Crows Nest Over Station Development

Submissions Report

This second Response to Submissions Report (November 2020) likewise responds to those submissions received in relation to the public exhibition of the Amended Project for the Crows Nest Over Station Development, including the request for additional information issued by the Department of Planning, Industry and Environment (DPIE) dated 15 October 2020.

SITE C

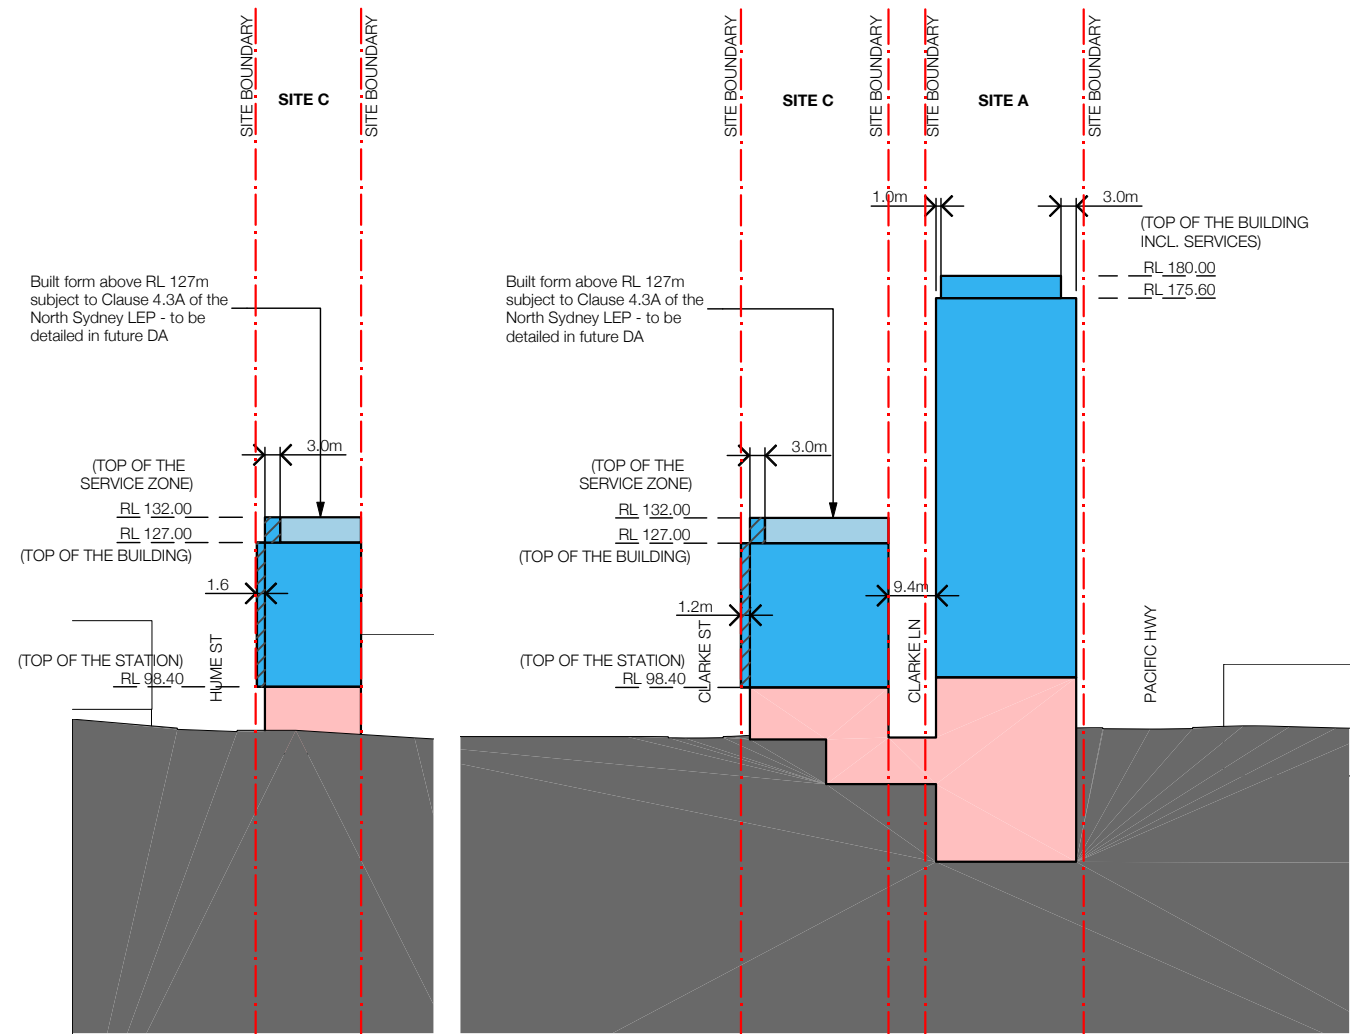
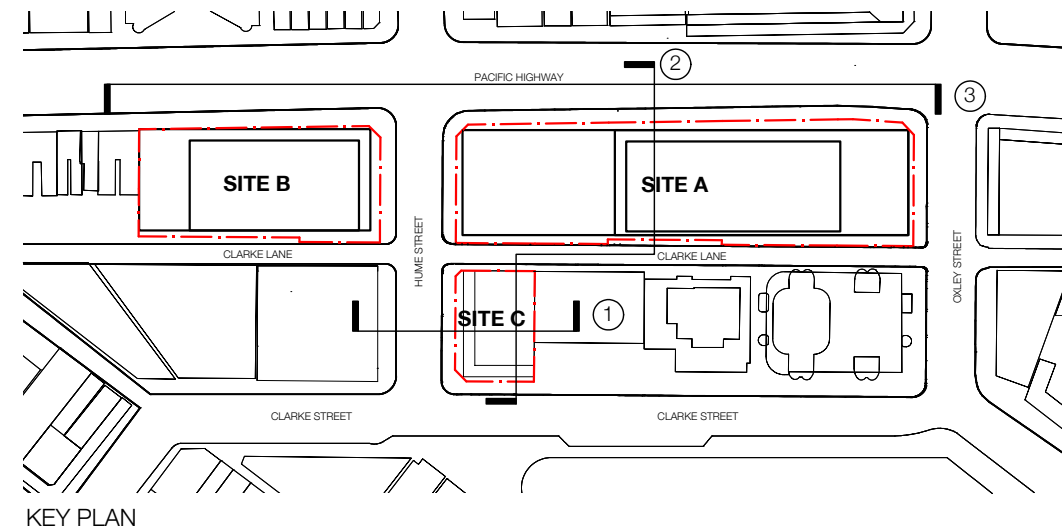
Extract	Response
<p><i>Specific concerns with revised concept plan.</i> Council raises specific concerns regarding the revised concept plans.</p> <p>Setbacks The proposed building envelopes have various setbacks to several frontages.</p> <p>Site A has a setback of between 1.5 metres and 3 metres from Pacific Highway in response to the design of the station box approved under 551 15_7400. The building envelopes are setback along Hume Street to allow for a 24 metre building separation between the buildings on Site A and Site B (SEPP 65 requirement). Site A and B are setback 2-2.8 metres and 1.2- 2.6 metres respectively along Clarke Lane to allow for future street widening. Site A is also set back approximately 1.5 metres along Oxley Street to align with the St Leonards Centre heritage item across Clarke Lane.</p>	<p>Noted.</p>

The station box has virtually set the base or podiums of the buildings. Council's DCP Character statement requires setbacks above the podiums and the proposal has provided the following:

Street	Required	Proposed
Pacific Highway	3m	1.5m Site A; Nil Site B
Hume Street	3m	1.5m Site A; 2.1m Site B
Oxley Street	3m	1.5m Site A
Clarke Street	3m	1.2m Site C
Clarke Lane	1.5m whole building	1.5m Site A; Nil Site C; Site B not shown

No setback shown on southern boundary of Site B. This is a residential building needing to satisfy SEPP 65 separation distances. The adjoining development is likely to be an eight storey mixed use building with 2 storey podium. Above podium development would be apartments. An absolute minimum side setback of 3m should be provided on each side to allow for some minimum separation, light and ventilation. The finalised form must not borrow or rely upon adjoining sites for separation.

The set back of Site B to Clarke Lane is an issue to ensure adequate separation between future residential buildings on the other side of the lane.

The proposed setbacks are indicated as articulation zones allowing for the buildings to be built closer to the boundary within the setback to allow for the articulation of the facades. It is noted that the articulation zone will not result in additional floor space. This would mean that greater setbacks than shown would need to be provided to compensate for floor area within the articulation zone.

The proposed building envelopes define the maximum possible extent of development on the site whilst also providing necessary flexibility for the future detailed design of the OSD.

As detailed in the SEPP 65 Compliance Analysis Report at Appendix I of the RTS Report, the indicative design for the proposed building envelope is capable of complying with the recommended Apartment Design Guide (ADG) building separation distances, and therefore the proposed Site B envelope can deliver a high quality and appropriate outcome. The indicative design achieves more than 24m separation between Hume Street and Pacific Highway and, along Clarke Lane, the lower floors of the residential building (below 25 m) achieve a minimum separation of 10m from the adjacent buildings. Along all other facades, the building achieves a separation of more than 12m. No habitable rooms are facing south-west and 6m separation to the boundary is provided and windows do not look towards neighbouring units. The indicative design represents one potential outcome for the proposed maximum building envelope, demonstrating compliance with the ADG building separation and privacy criteria.

The proposed articulation zones have been removed from Sites A and B, and further objectives and controls have been developed for the articulation of the maximum building envelopes in the Design Guidelines (see Appendix B). These include:

- enabling a maximum plate depth of 27.5 metre, floor plate area of 2,750 square metres, and a minimum 15 per cent of the building envelope to be used for articulation ensuring that the proposed maximum building envelopes will be appropriately refined as part of the Detailed SSD Applications
- the maximum floor plates specifically also ensure that the commercial uses on Site A will benefit from generous access to light and air, and enables the flexible use of space in providing opportunities for multiple subdivisions and layouts for the commercial levels
- the tapered setback envelope of the Site A also allows the floor plates to gradually reduce towards the upper levels providing range of floor plate sizes within the development, which diversify the opportunities for future tenants.
